Regarding planning application No: 3/2022/1158

Proposal : Erection of 17 dwellings and 57 apartments with associated access, roads, car parking, landscaping and infrastructure, including a public car park to serve Whalley town centre.

Location: Land South of Accrington Road Whalley.

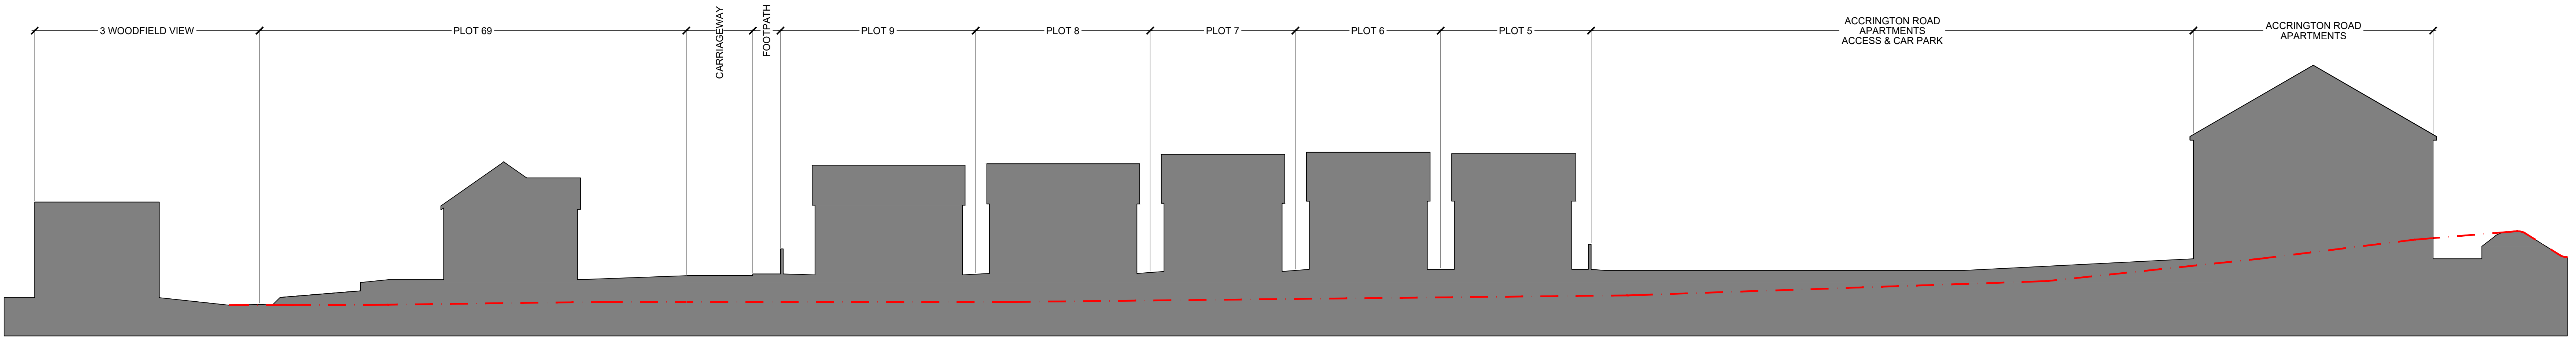
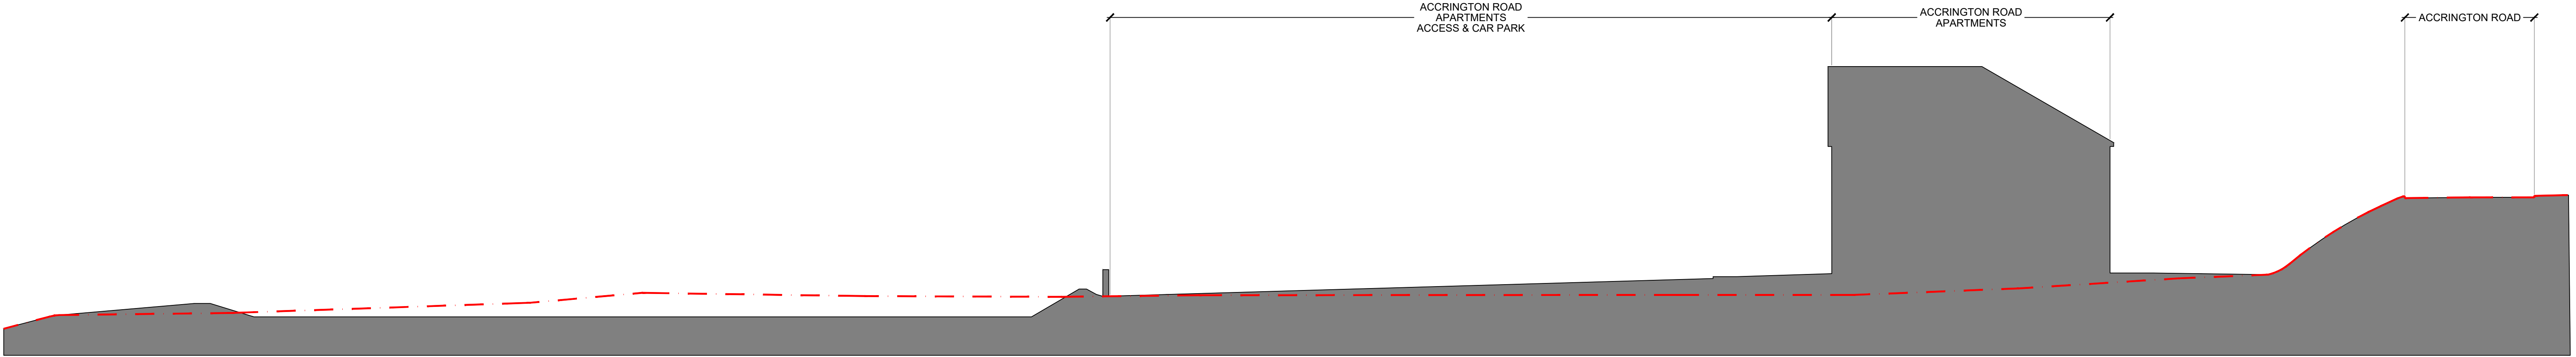
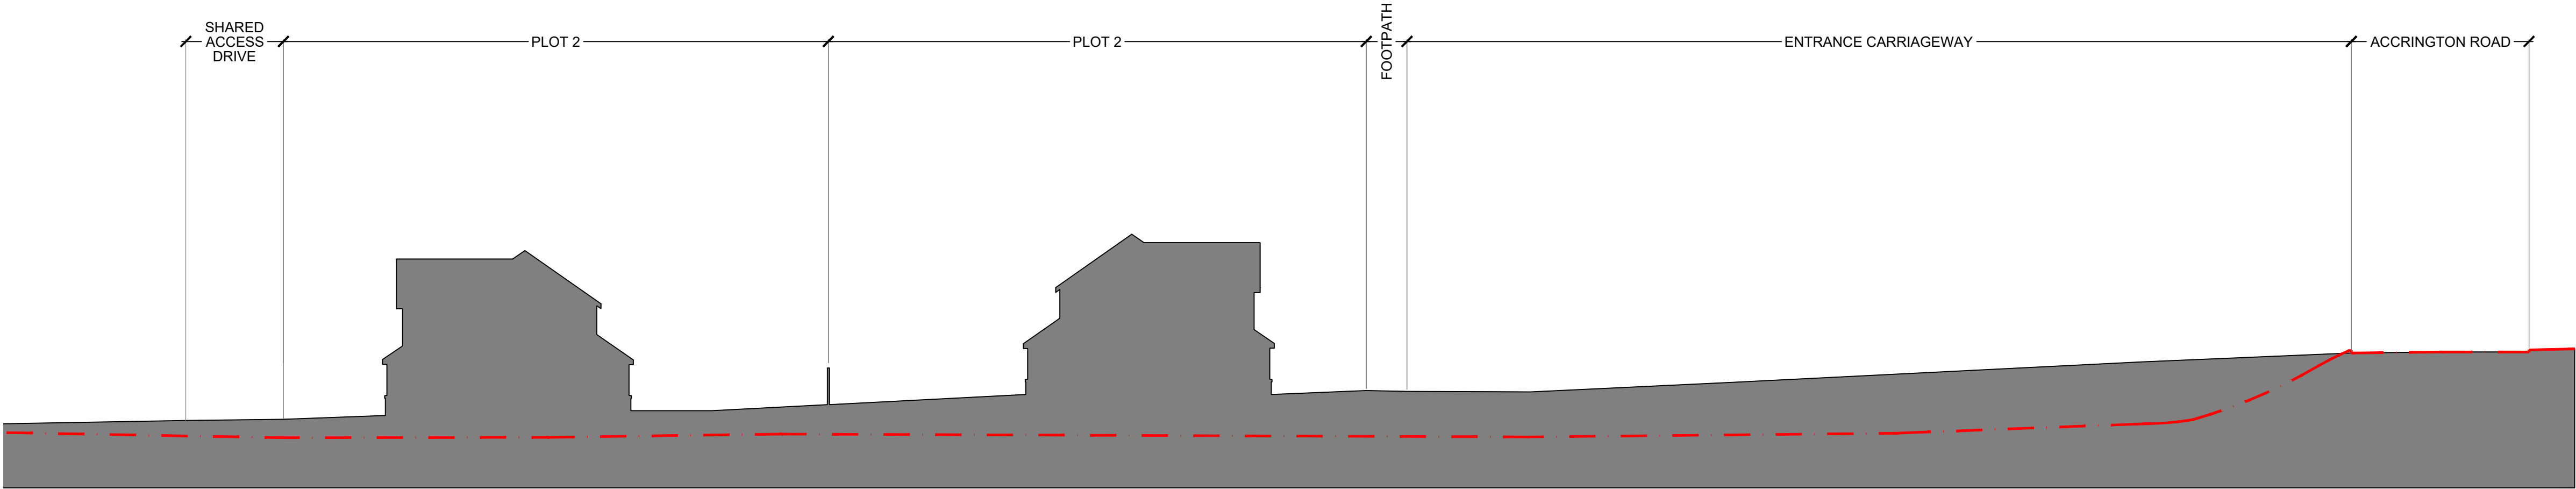
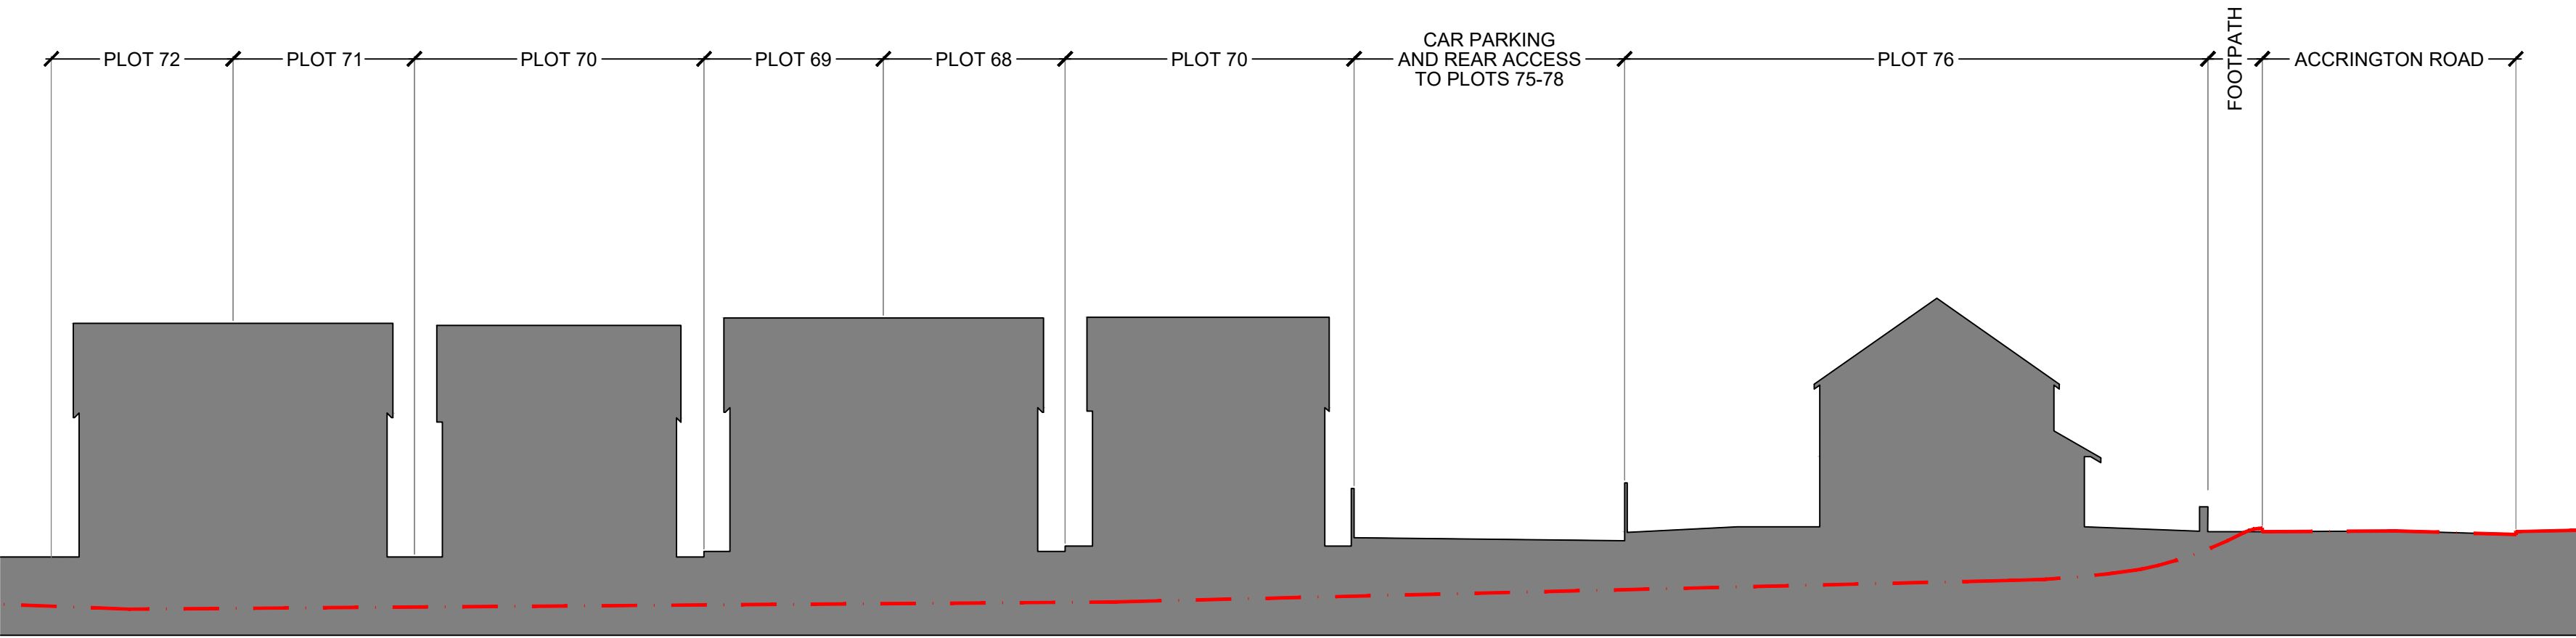
Comments: The buildings are too tall and are incongruous with street scene and definitely a loss of amenity space. 3 stories are too tall considering that the land is being raised as well
